STATE OF NORTH CAROLINA
DEPARTMENT OF TRANSPORTATION

Addendum No. 1

RE: Contract # C204312

2 Sections Of NC-39, 2 Sections Of US-401 And 10 Sections
Of Secondary Roads

PROJECT REFERENCE NO.	SHEET NO.
2020CPT.05.13.10911.1,etc.	5

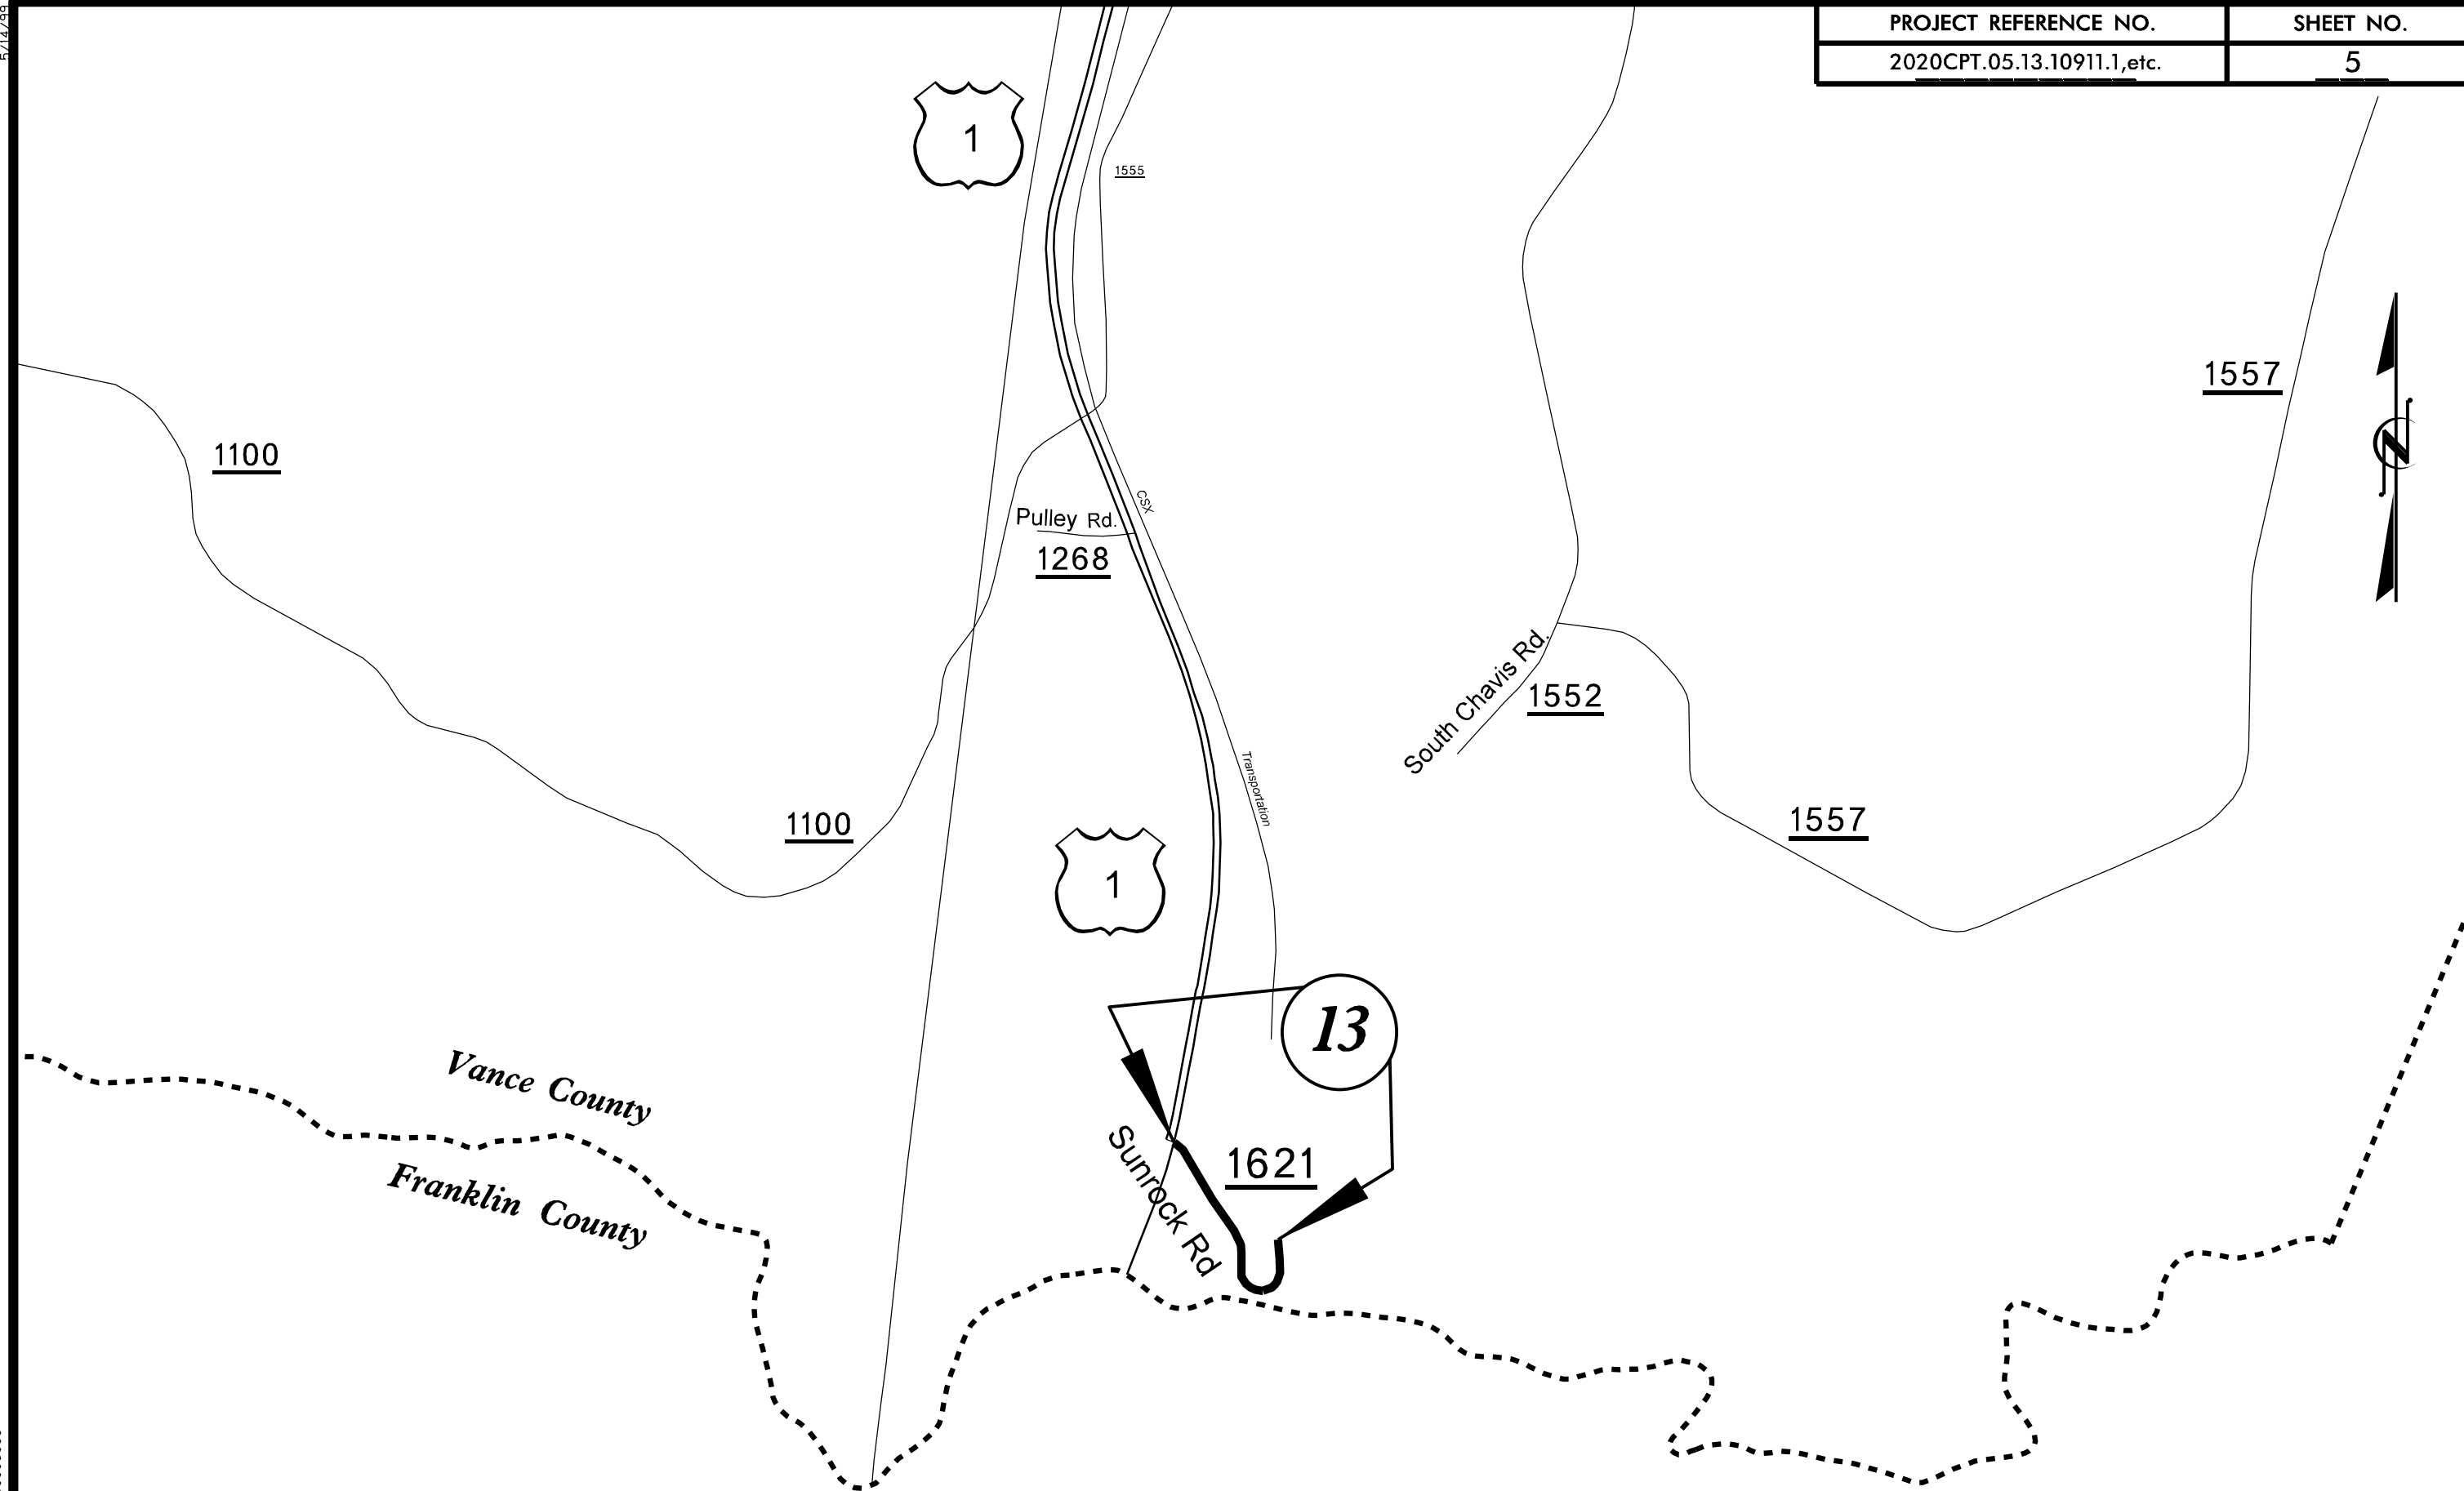
Sheet No.	Revisions
5	Deleted. Map #13 eliminated from project.
10 and 11	Deleted reference to Map #13. Revised "Summary Of Quantities" to reflect the pay item changes as described below
